May 23<sup>rd</sup>, 2023

RE: Ceja Vista  
10001 Ceja Vista Road SW  
Zone: R2  
Submittal: TCL for Final C.O. of Phase 1

SHEET NO.

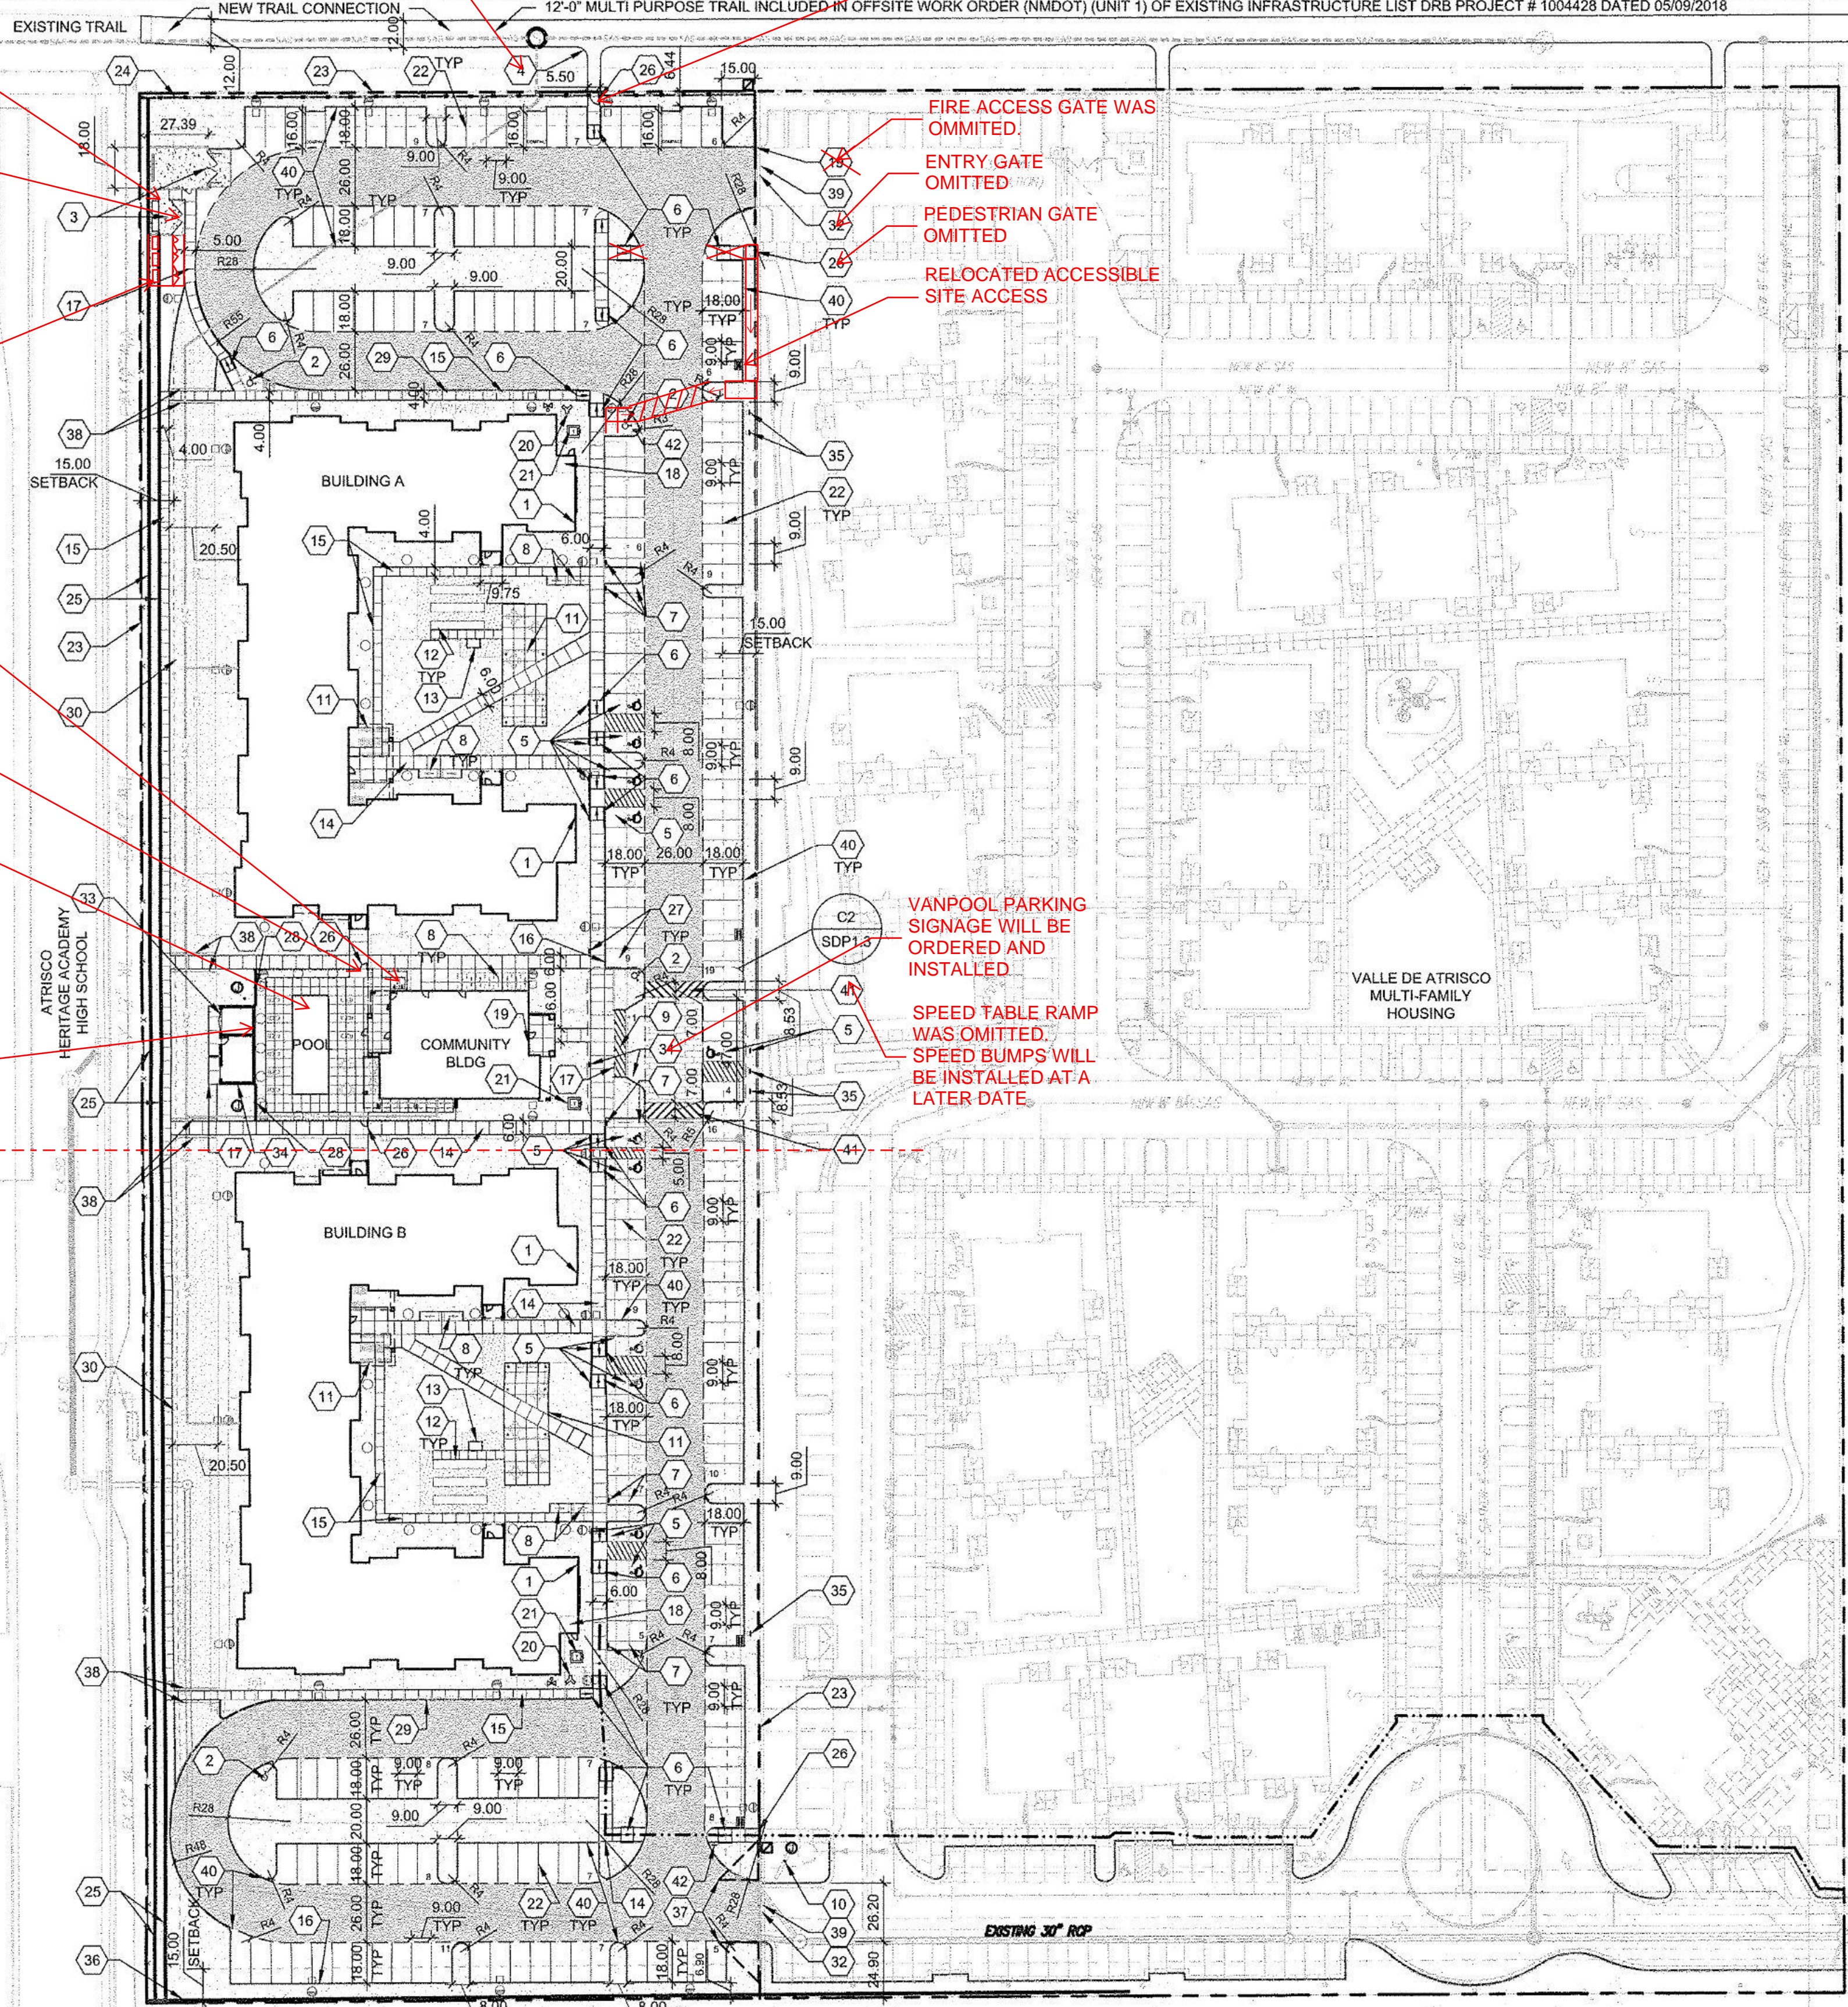
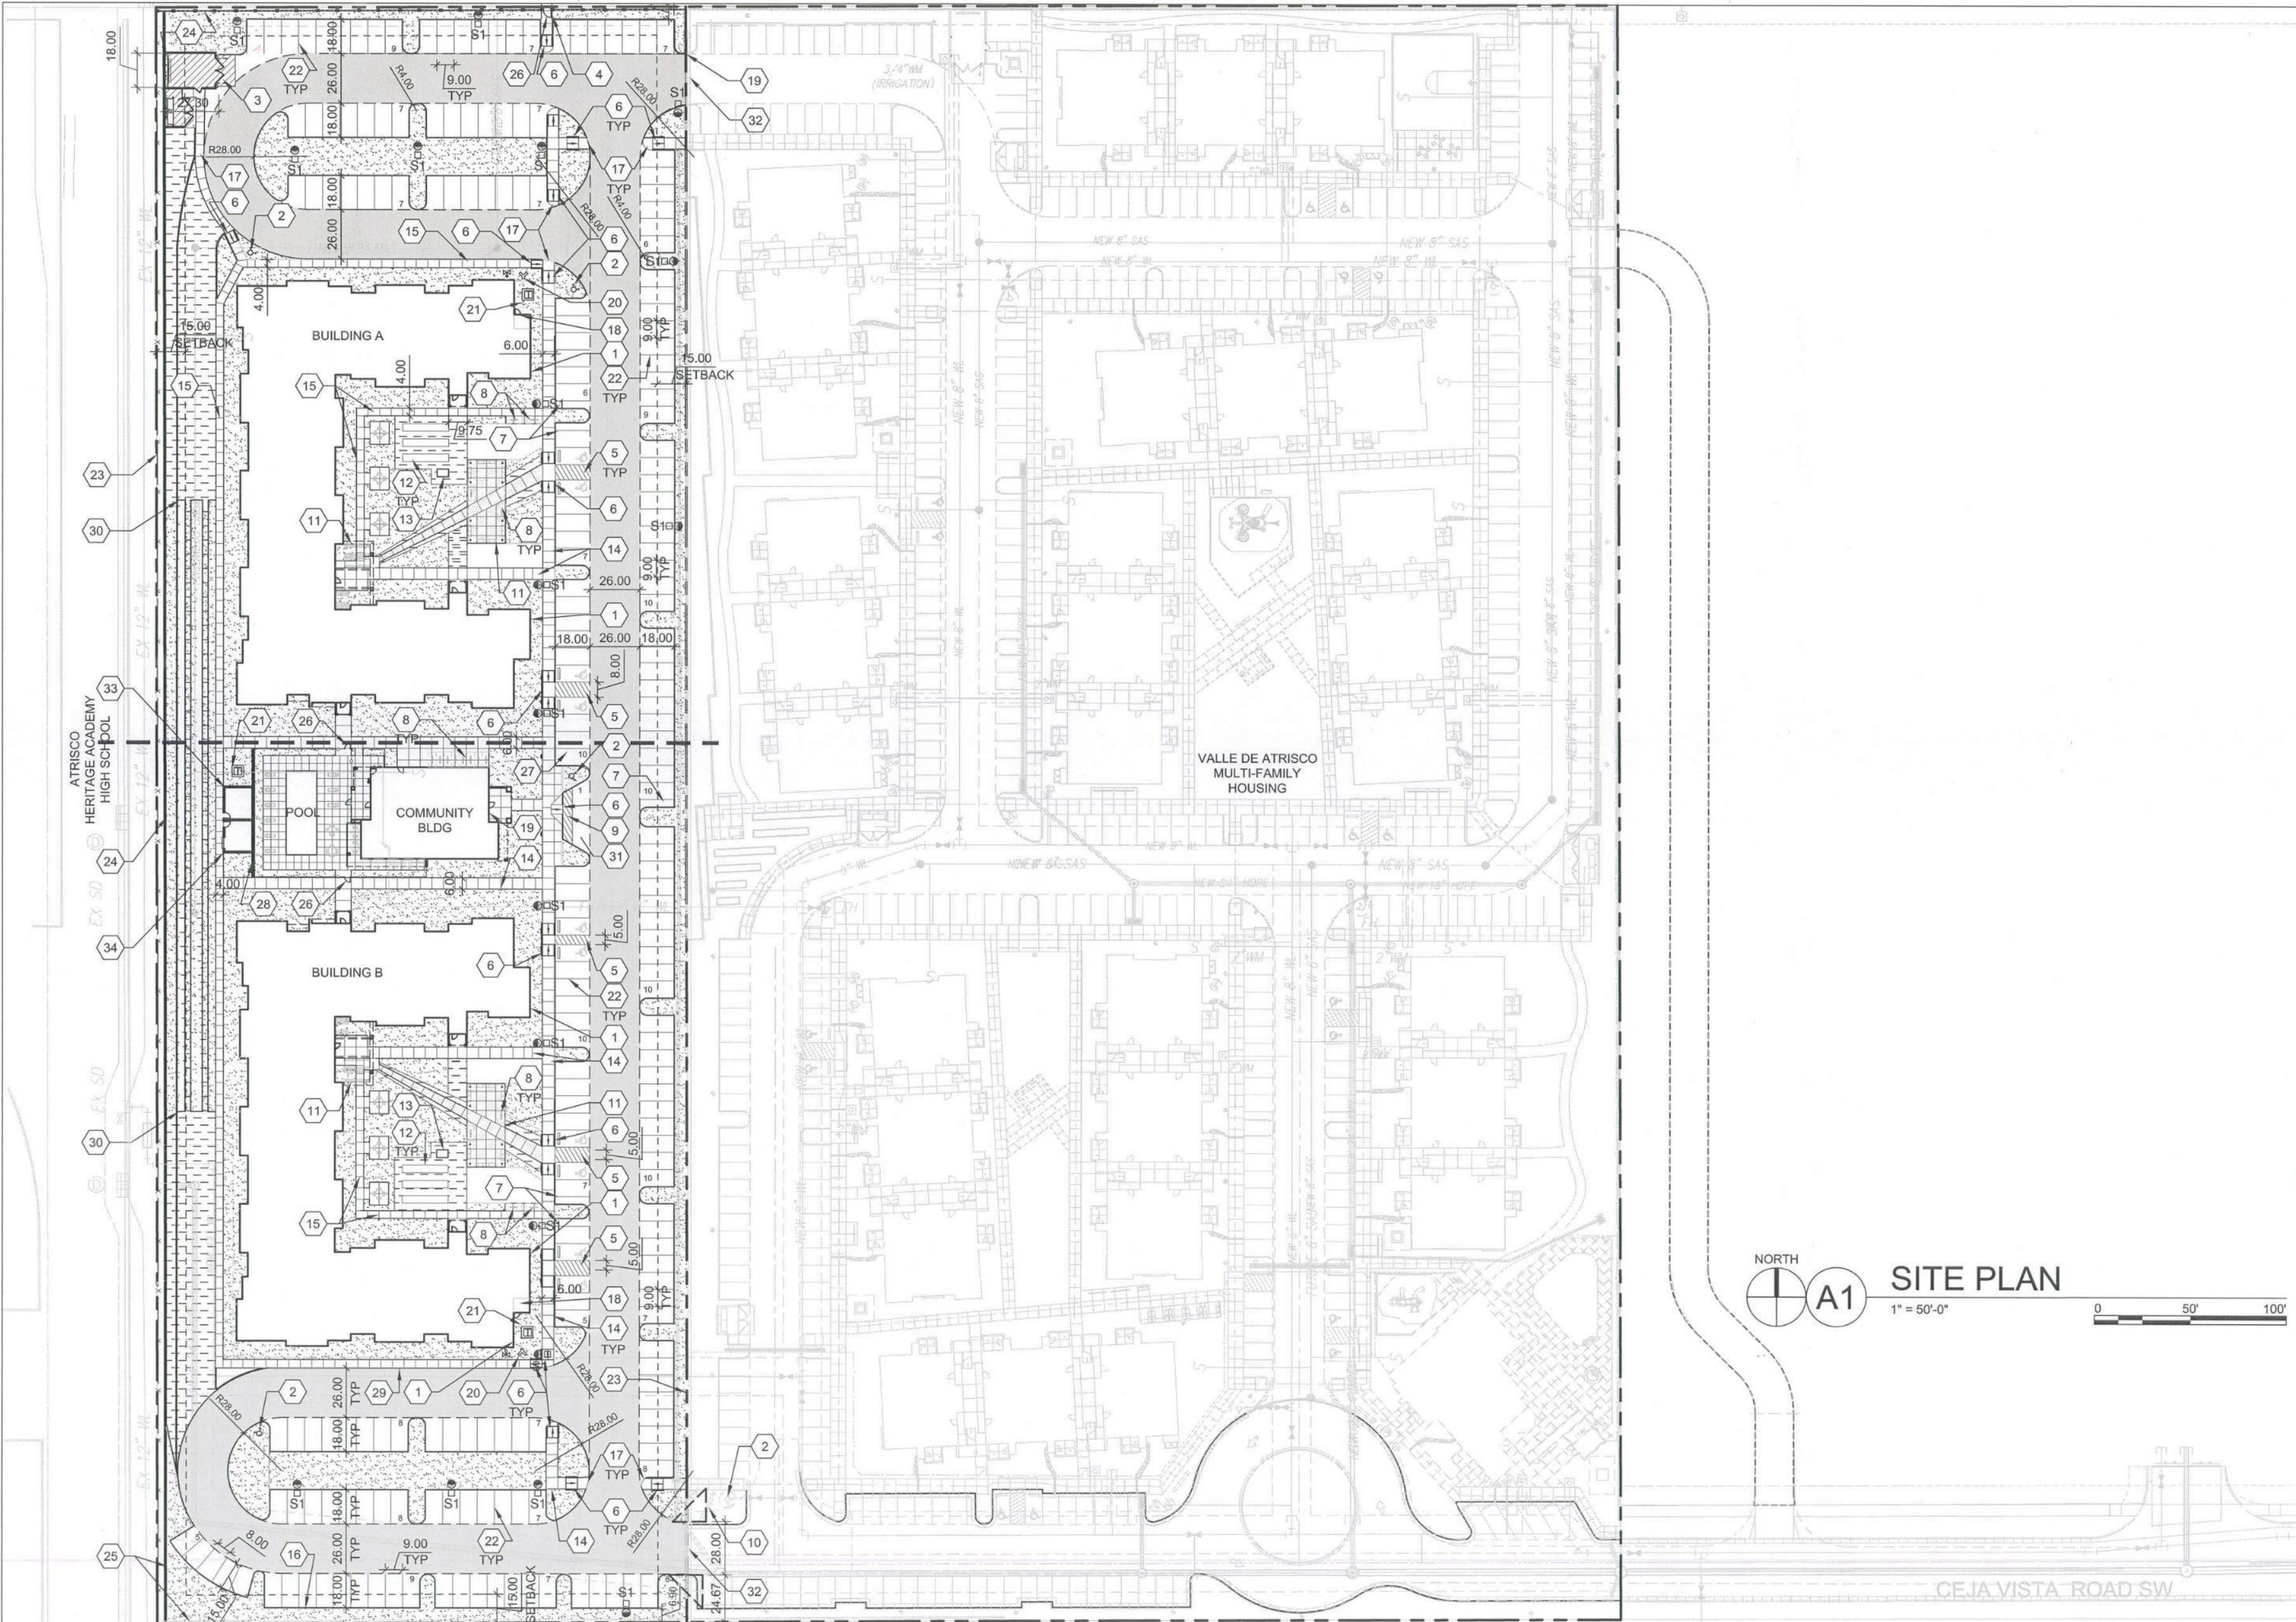
- Fire access gate was omitted during construction. Knox Box no longer required at this location.
- City Comment Response - Pedestrian gate has been installed as of 5/22/2023 and walkway connection to Dennis Chaves Blvd. have been installed as of 5/22/2023:

- ADA access route was revised and red lined on plan.
- 2 sidewalk ramps were omitted per changes in the ADA access route.
- Block wall at Trash Compactor is in progress. It is currently at 6'-8" and the final height is 9'-4".
- Gates at Trash Compactor and Enclosure have been installed as of 5/22/2023.

- Trash Enclosure was revised to accommodate 5 trash bins from 2 bins. Changes have been approved by Solid Waste and COA.
- Pool and outdoor showers were omitted during construction. Artificial turf and a shade structure were installed in place of the pool.
- Fence around opens space has been revised and installation is in progress as of 5/22/2023.
- Building mounted lights are not yet installed.
- City Comment Response - Van Pool Parking signage has been installed as of 5/23/2023.

- Speed table and stamped concrete were omitted during construction. Speed bumps will be installed at a later date.
- City Comment Response - Pathway striping at speed table was omitted during construction with omission of speed table.
- City Comment Response - Van accessible aisles have been revised to be 8 feet wide as of 5/23/2023.

- City comment Response – Sidewalk in front of Trash Enclosures has been revised to be 5 feet wide per plans.
